Engineers Comments Regarding Surface Water Drainage

Application Reference:	A/20/26/DOC	Reviewer Reference:	ADC/EXT5/AF
Planning Officer:	Hannah Kersley	Date of Review:	26/03/2026
Site Name:	Land North of Water Lane Angmering BN16 4EJ		
Application Description:	Approval of details reserved by condition under A/248/21/PL relating to condition 29 -As Built Drainage.		
Assessment Number:	2

Application Reference: A/20/26/DOC Site Name: Land North of Water Lane Angmering BN16 4EJ	Initial Issue Date: 26/02/2026 Issue Date: 26/03/2026 Reviewer Reference: ADC/EXT5/AF
--	---

Manhole Ref.	Proposed Invert Level	As-Built Invert Level	Length	Proposed Pipe Gradient	As-Built Pipe Gradient
S3072	33.354m	33.331m	22.26m	1/24	1/24
S1418	32.304m	32.400m

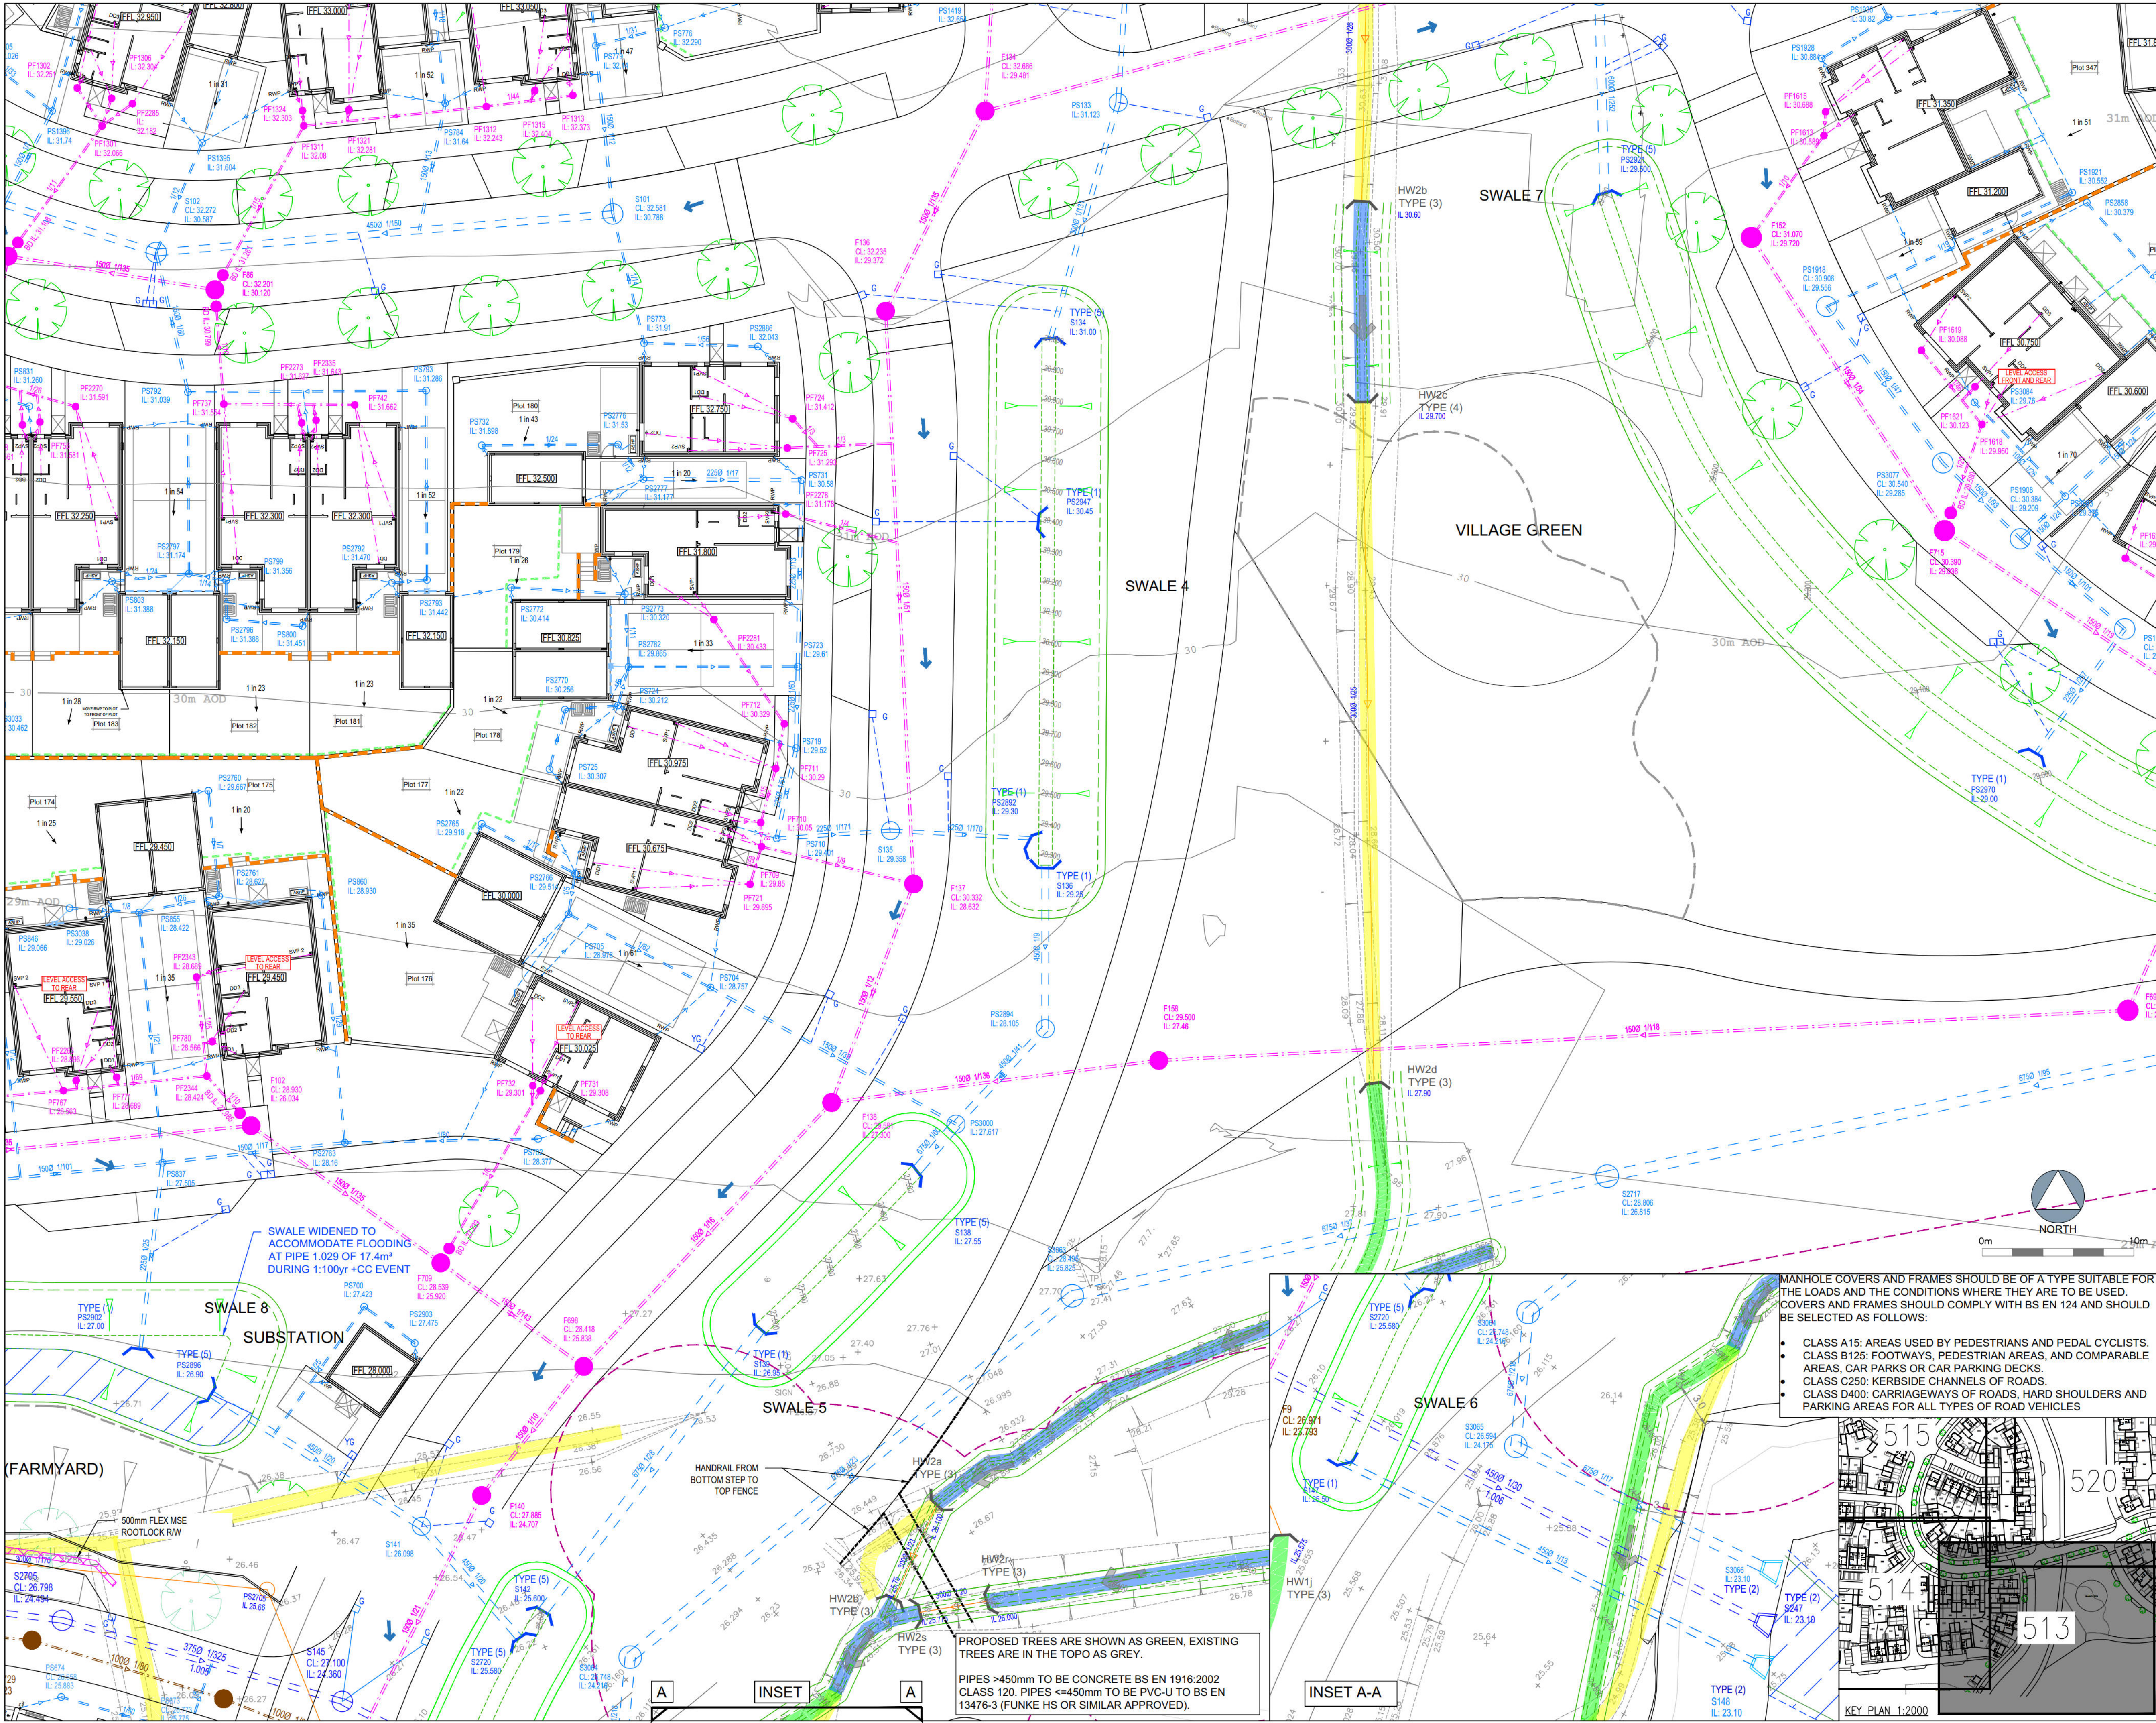
8.	S101 has an IL deviation of 344mm. Confirmation of no adverse effect on the functioning of the system is needed to support this change.	S101 is at the head of the drainage run. The diameter of the outgoing pipe is 450mm and its constructed fall gradient is 1/181 (refer to As Built Drainage Variations - Variation 6, paragraph 2.22), therefore there are no adverse effects on the drainage system.	Comment closed.

189.5005.1355

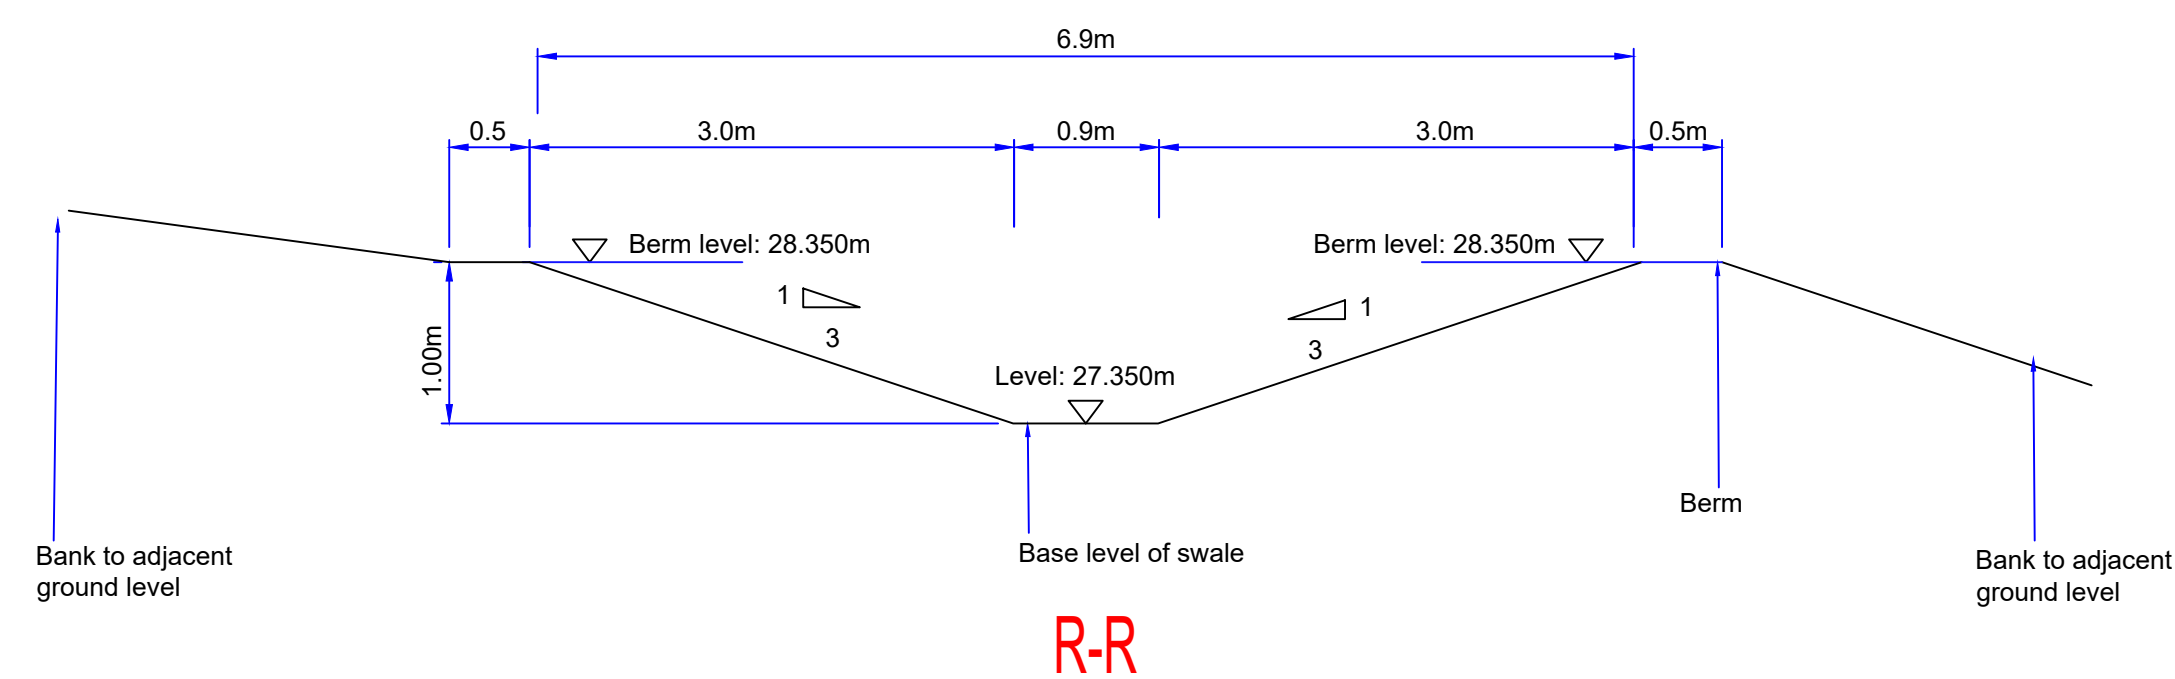
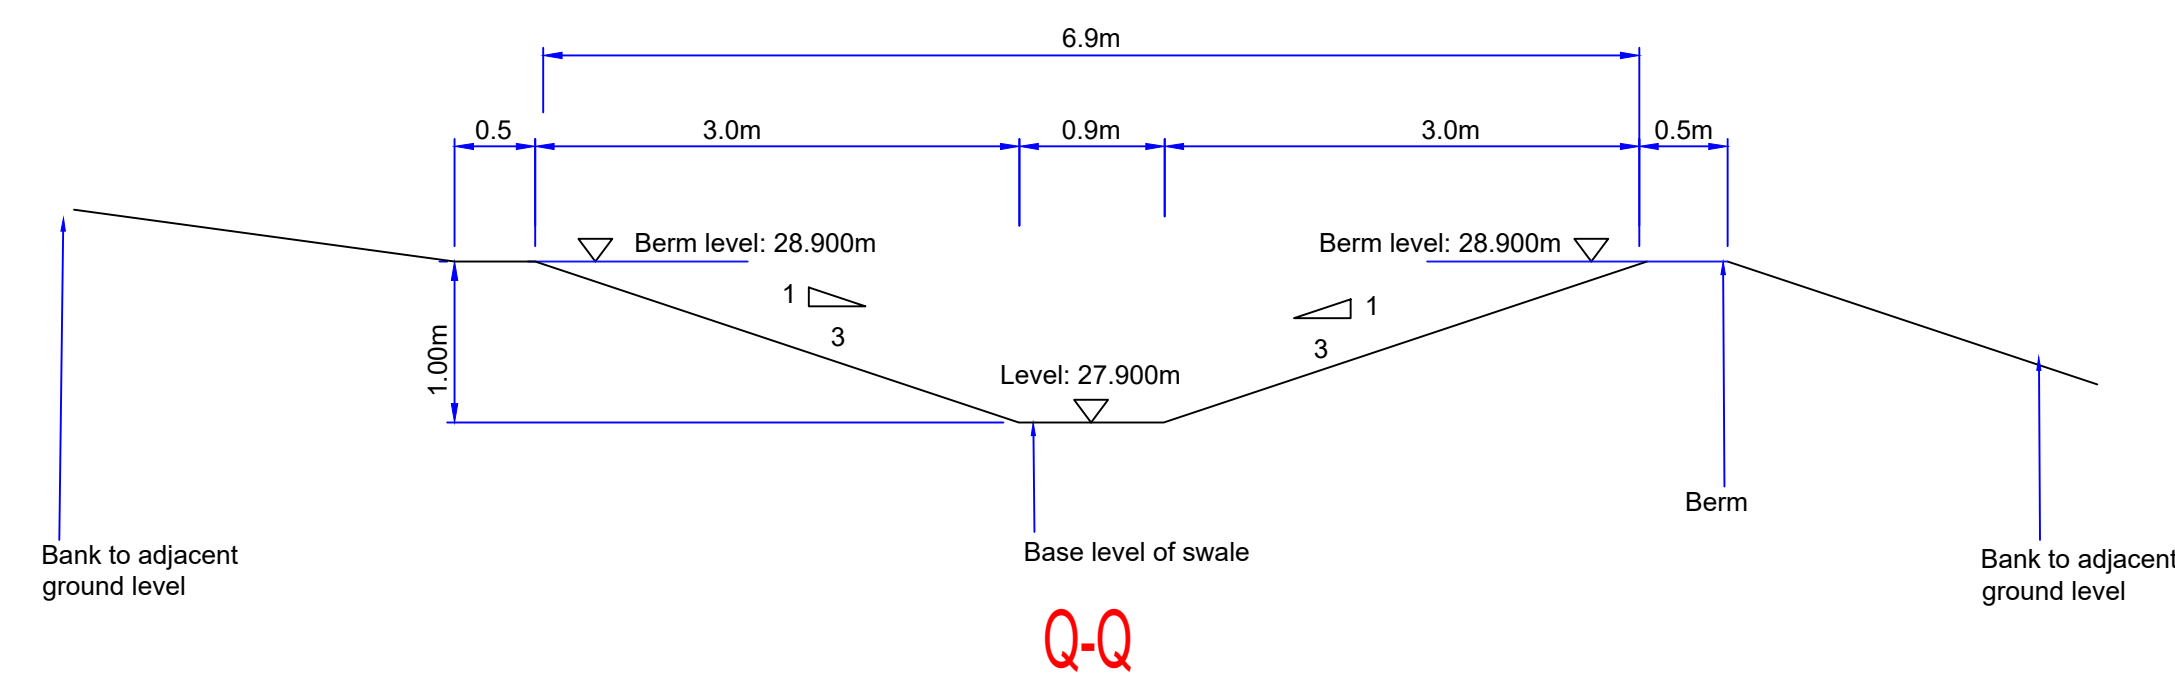
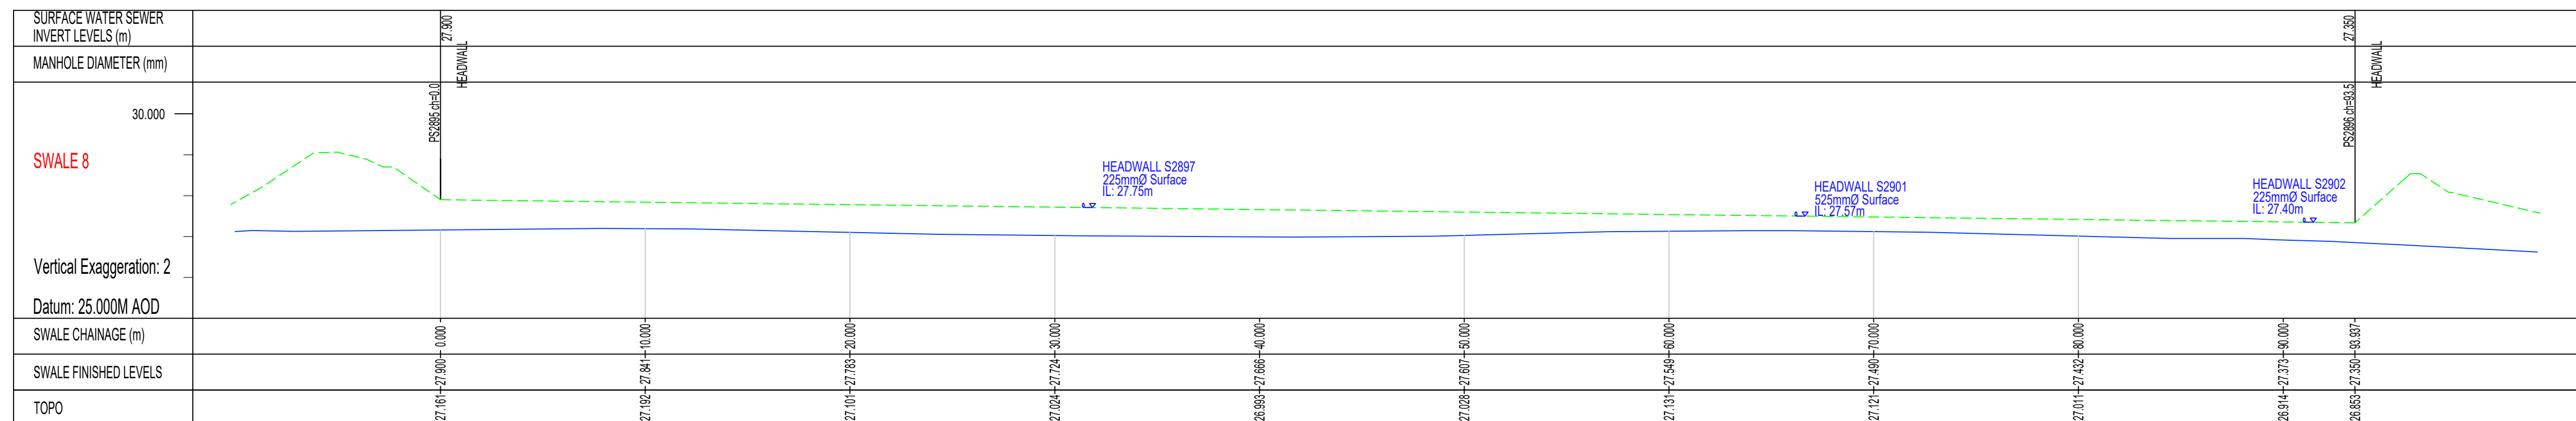
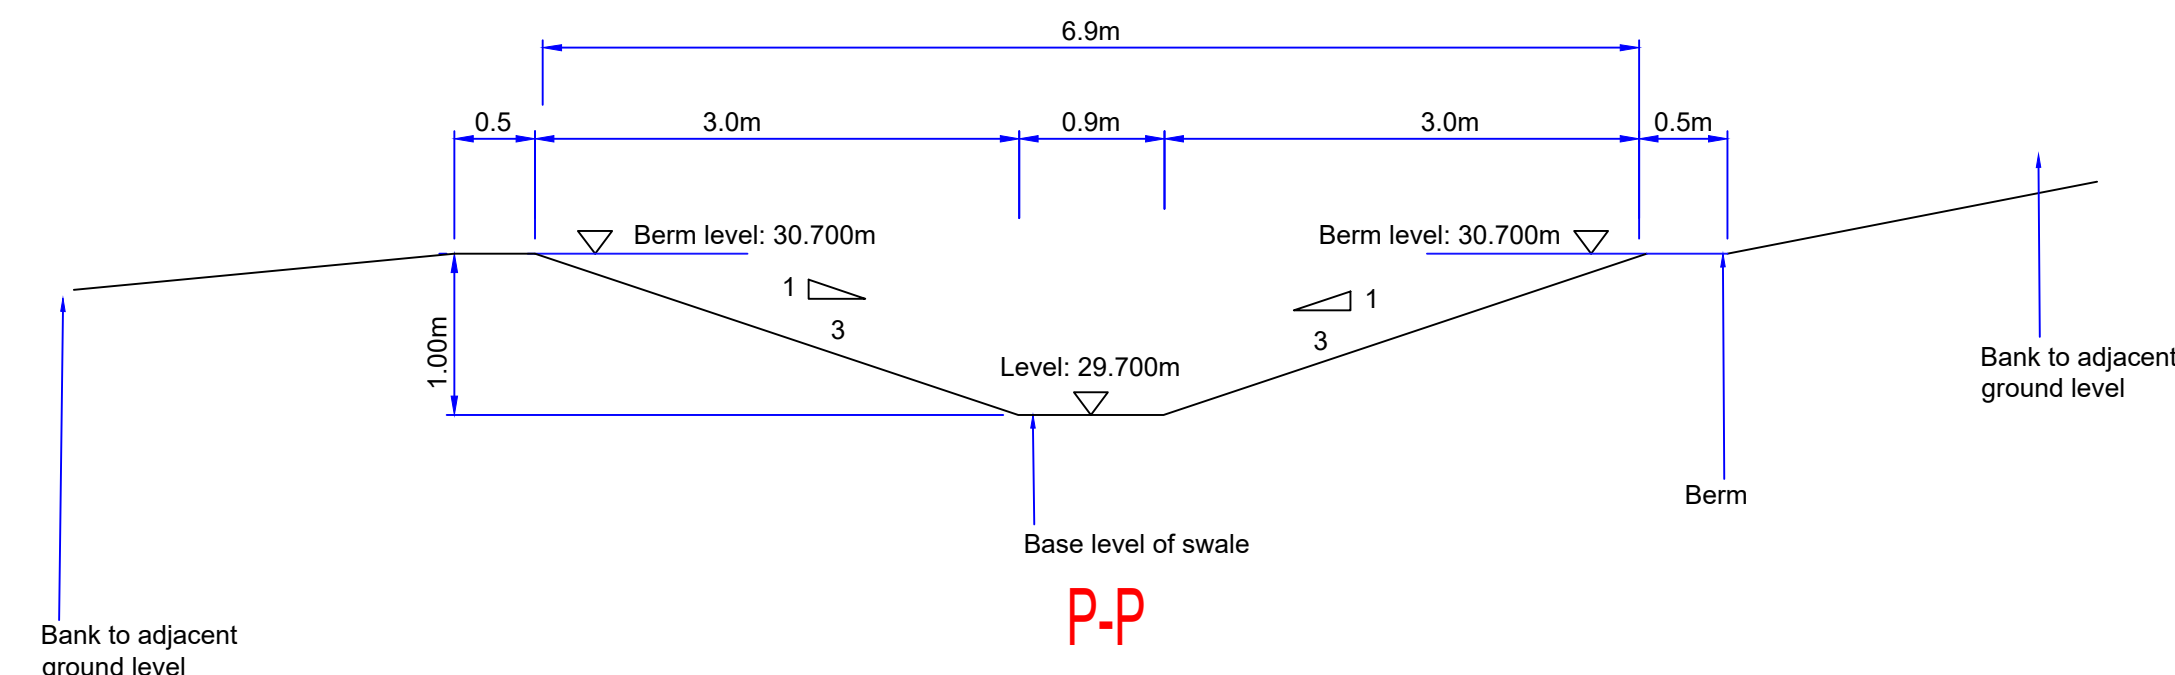
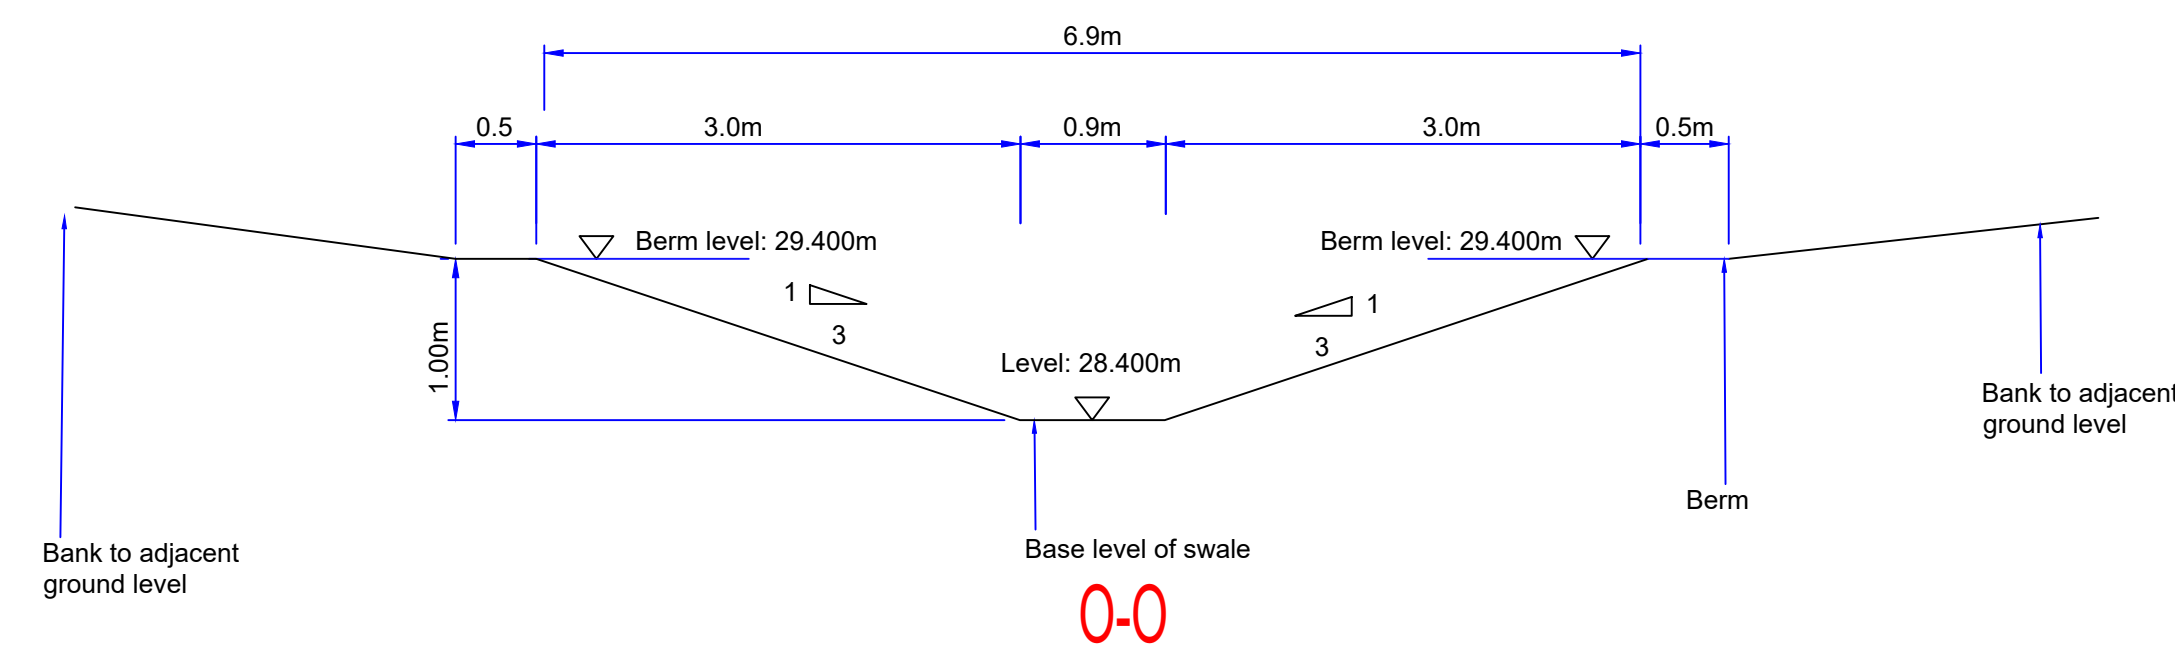
5.	The swales include storage provision and/or design storm flows as part of the sustainable drainage system. An as built measured survey should be provided and confirmation through volumetric comparison with the approved technical design that the as built capacity is fit for purpose.	The volume of the constructed swale has been calculated and can be found in Appendix M. The proposed Drainage Layout states that 17.3m3 of storage is required in this swale to manage the surface water runoff in a 1 in 100 year + 40% climate change storm event, therefore the constructed basin provides greater storage volume than required.	The information in Appendix M cannot be verified. Please provide the as-built topographical survey plans together with a volumetrics plan at a readable scale. There are three swales included in the Phase 2.1 area.
